WEST SUSSEX COUNTY COUNCIL CONSULTATION

TO:	Arun District Council FAO: Simon Davies
FROM:	Highways, WSCC
DATE:	17/08/2018
LOCATION:	1, Finch Gardens, Bersted, PO22 9EQ
SUBJECT:	BE/74/18/PL Erection of 1 No. attached dwelling.
DATE OF SITE VISIT:	
RECOMMENDATION:	☐ Advice ☐ Objection ☐ Modification ☐ No Objection ☒ More Information ☐ Refusal
S106 CONTRIBUTION TOTAL:	£N/A See below for breakdown.

CLIENT	PROJECT	TITLE	STATUS	DRAWN BY	REVIEWED BY
KELLY WESSON	1 FINCH GARDENS NORTH BERS TED	ATTACHED DWELLING PROPOSED FL DOR PLANS	PLANNING	SJ	SJ
			DATE	SCALE	
			13.06.2018	1:50@A1	
			DRAWING NUMBER		
			ADC/9/18 – 14

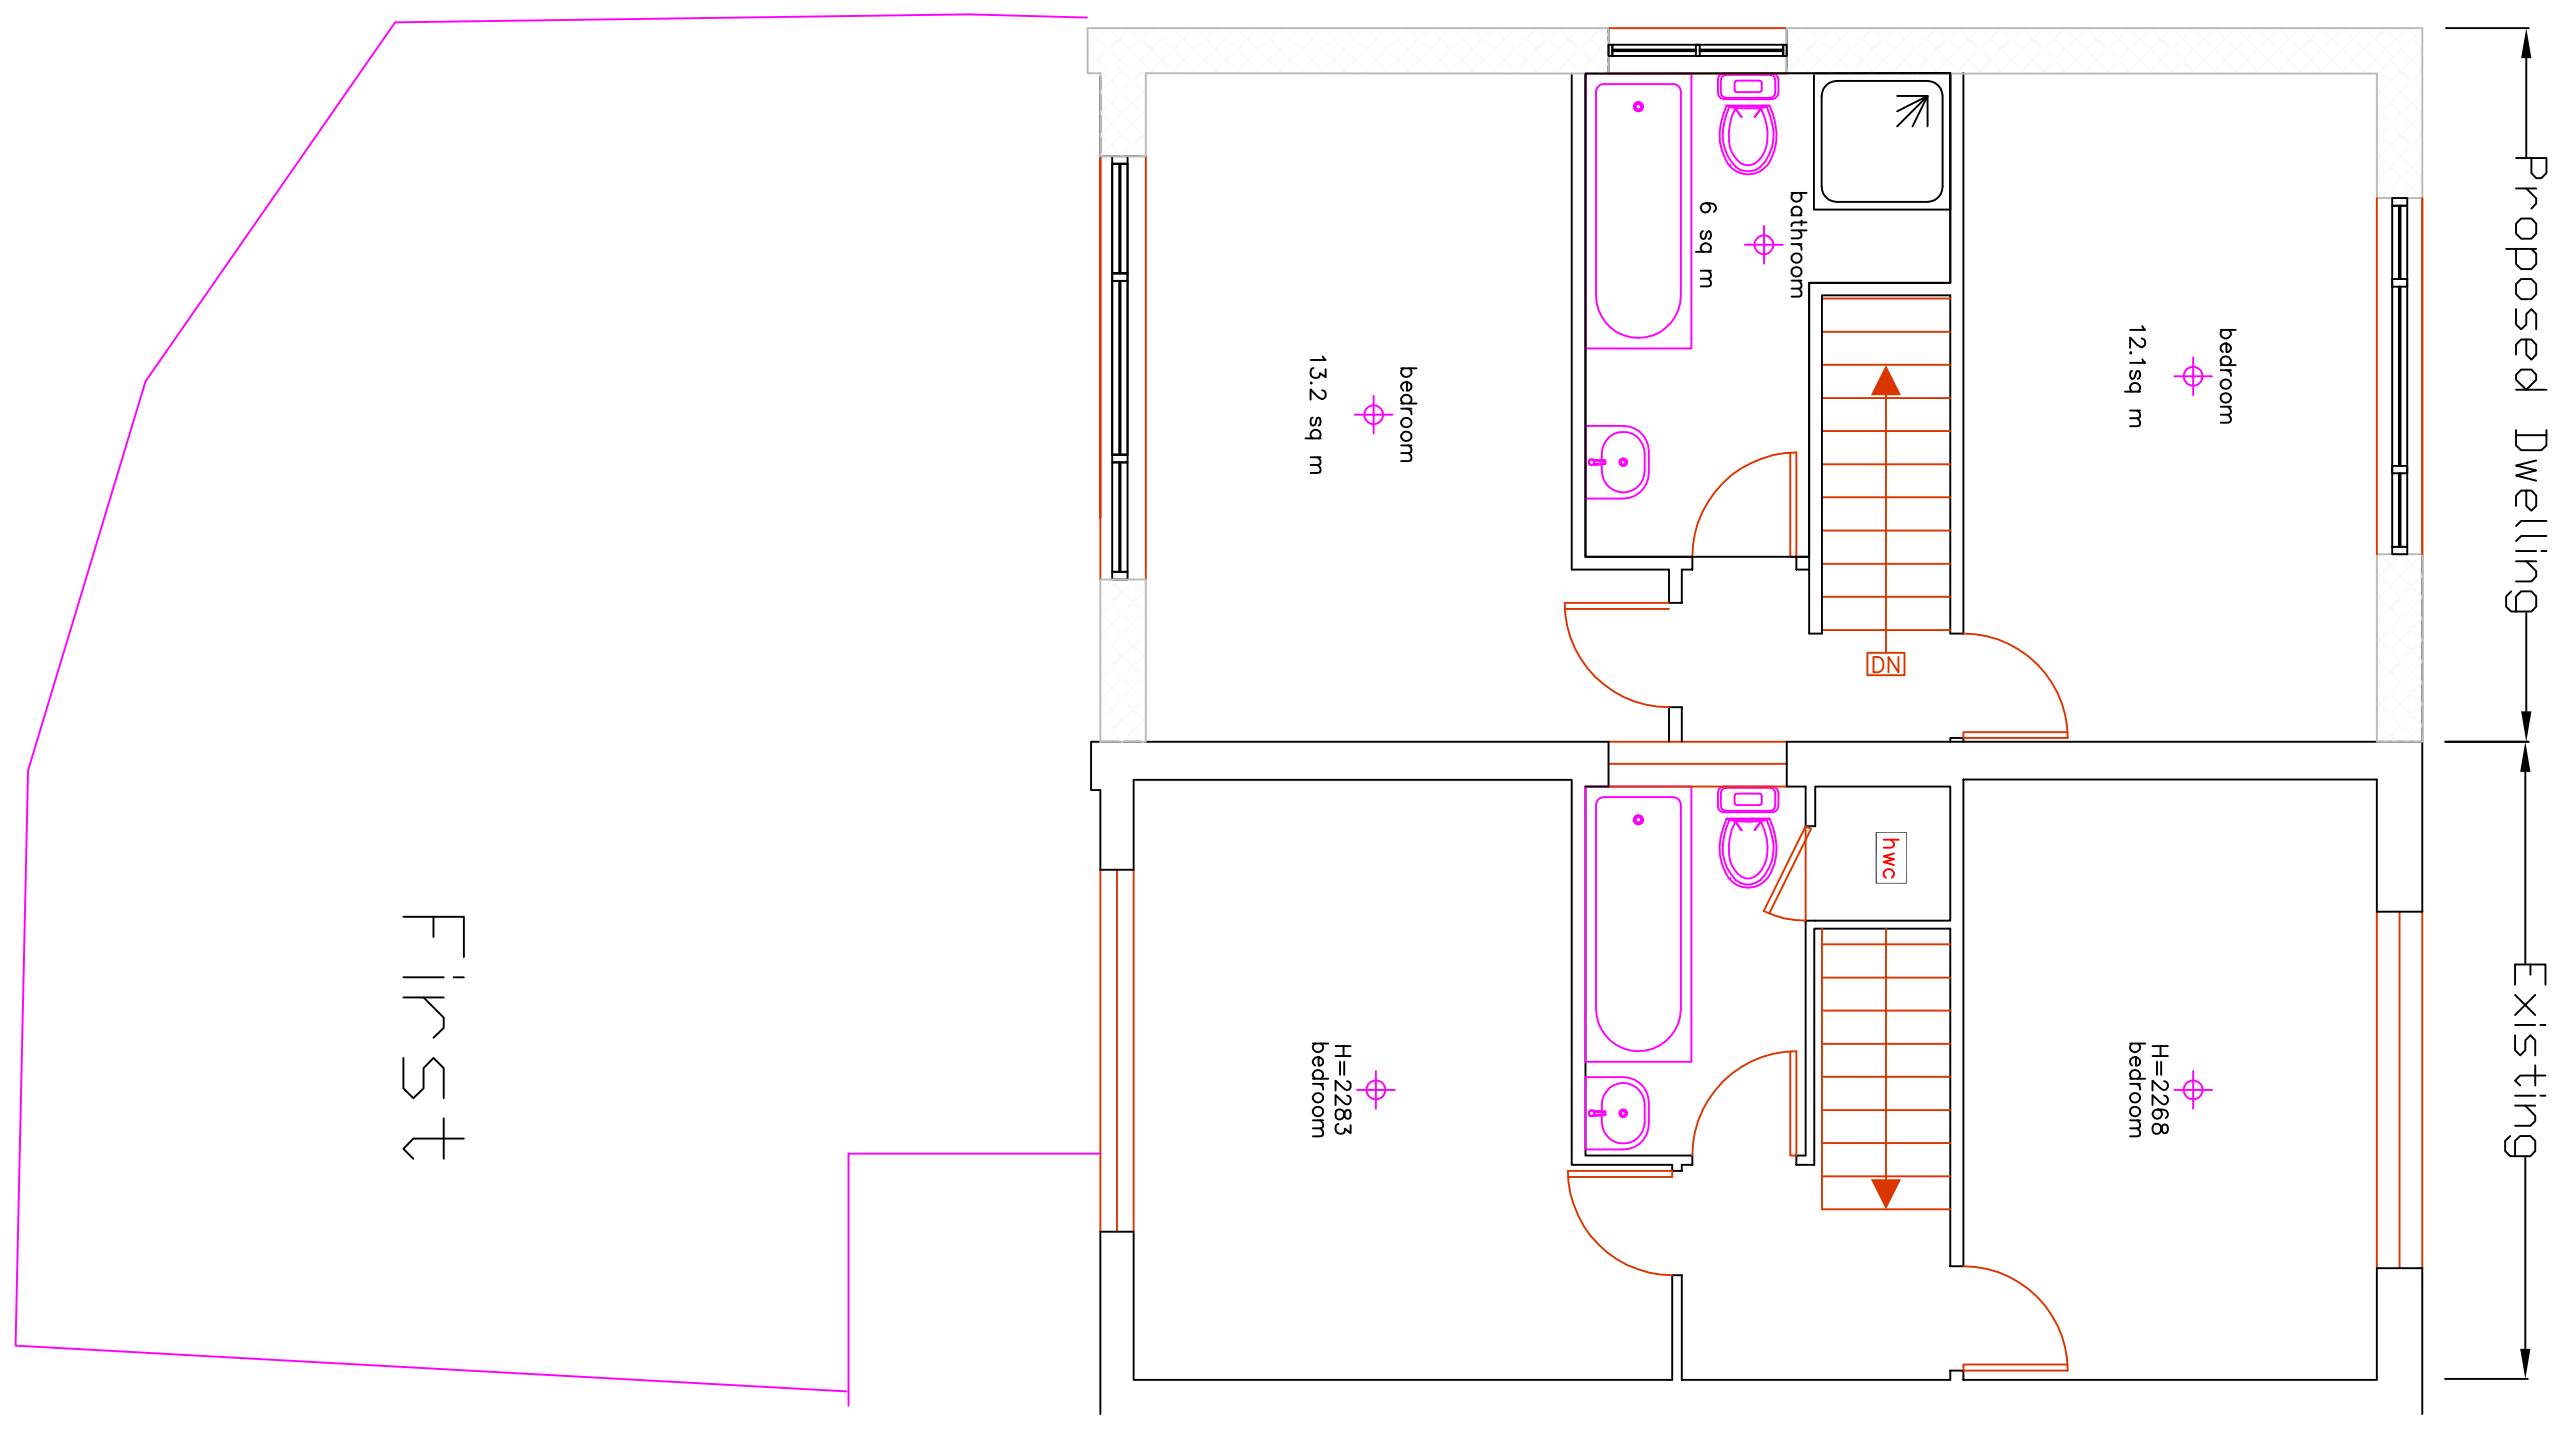
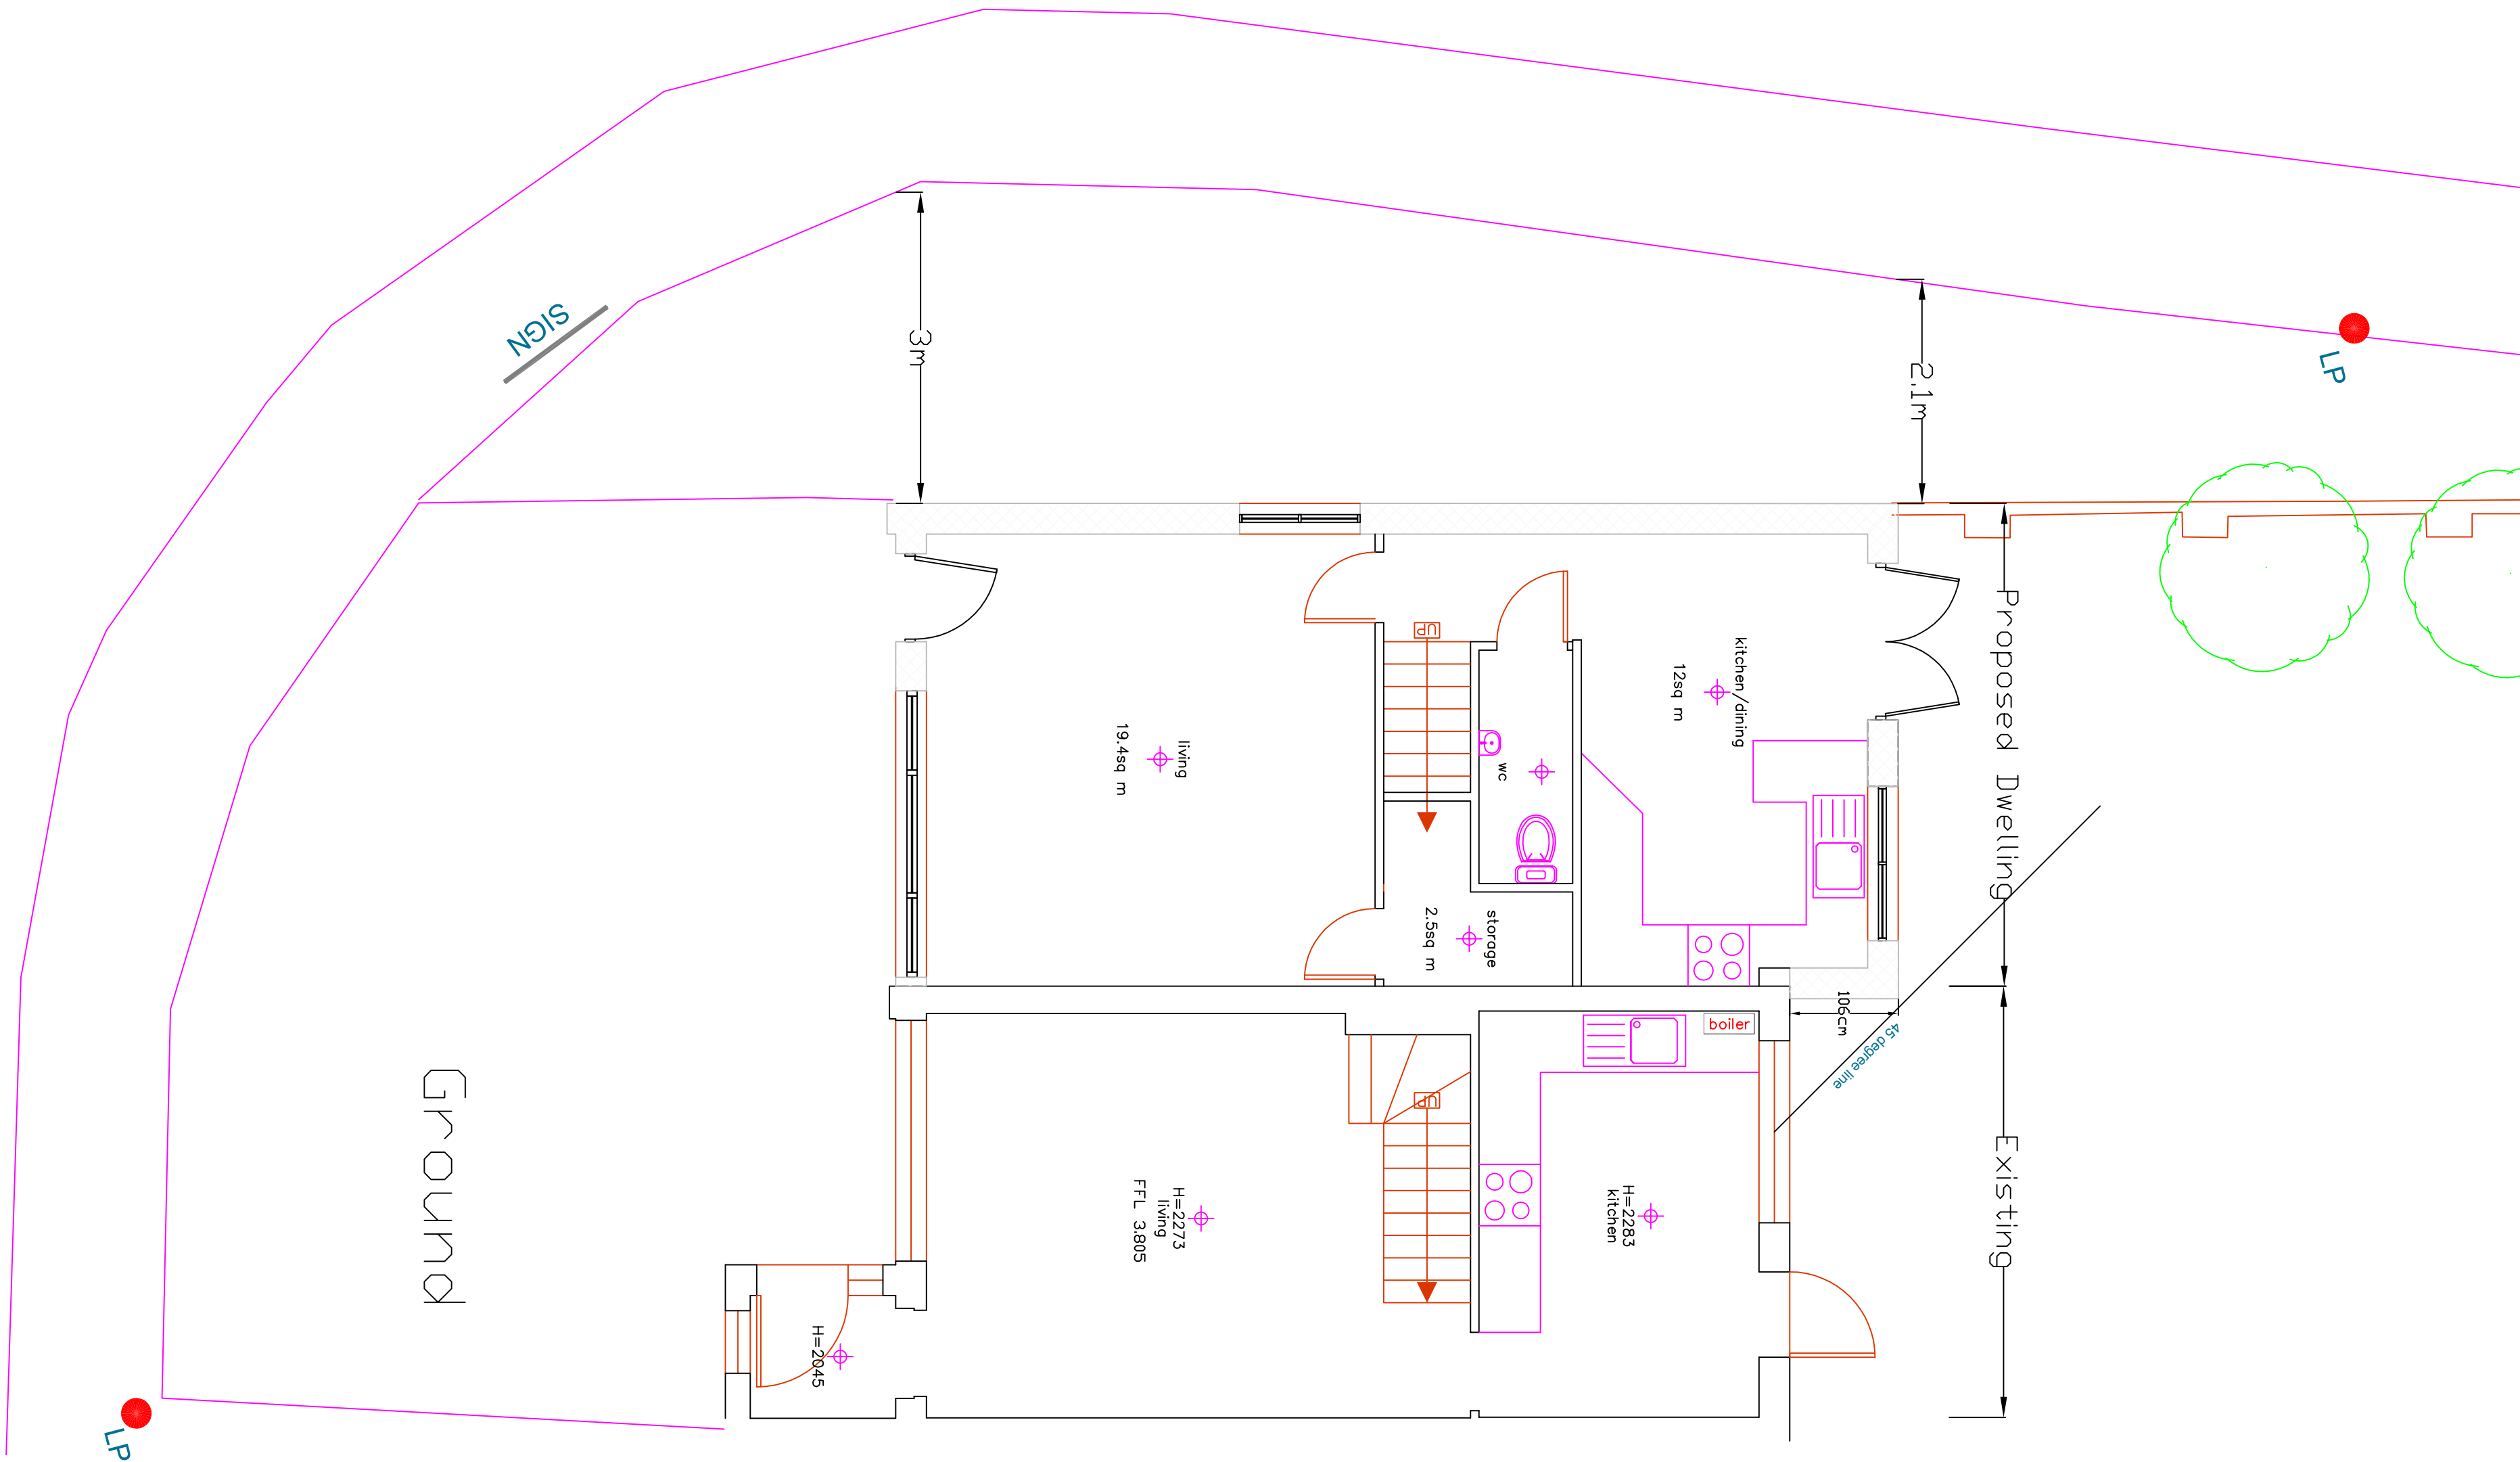
In order to allow legal access to the proposed parking on the frontage for both the existing and proposed dwelling, the current extent of the dropped kerb would need to be extended or a new vehicle cross over (VCO) would need to be created. The extent of the required dropped kerb should be shown on a plan.

The applicant would be responsible for liaising with the relevant utility company and other relevant parties to relocate the lighting pole at least 1.5m from the edge of the proposed dropped kerb, as well as covering the cost of the relocation works.

The WSCC car parking calculator would envision a total of 5 car parking spaces for both the existing and proposed dwellings. The minimum car parking dimensions as stated in Manual for Streets (MfS) are 2.4m x 4.8m. The parking area for the existing dwelling would only be wide enough to accommodate 1 car parking space that meets MfS standards. The parking area for the proposed dwelling is not deep enough across the total width to accommodate 2 vehicles without overhanging the footway, therefore only 1 car parking space that meets MfS standards can be provided for this dwelling also.

The applicant should provide a plan showing the proposed extents of dropped kerb required before re-consulting the LHA.
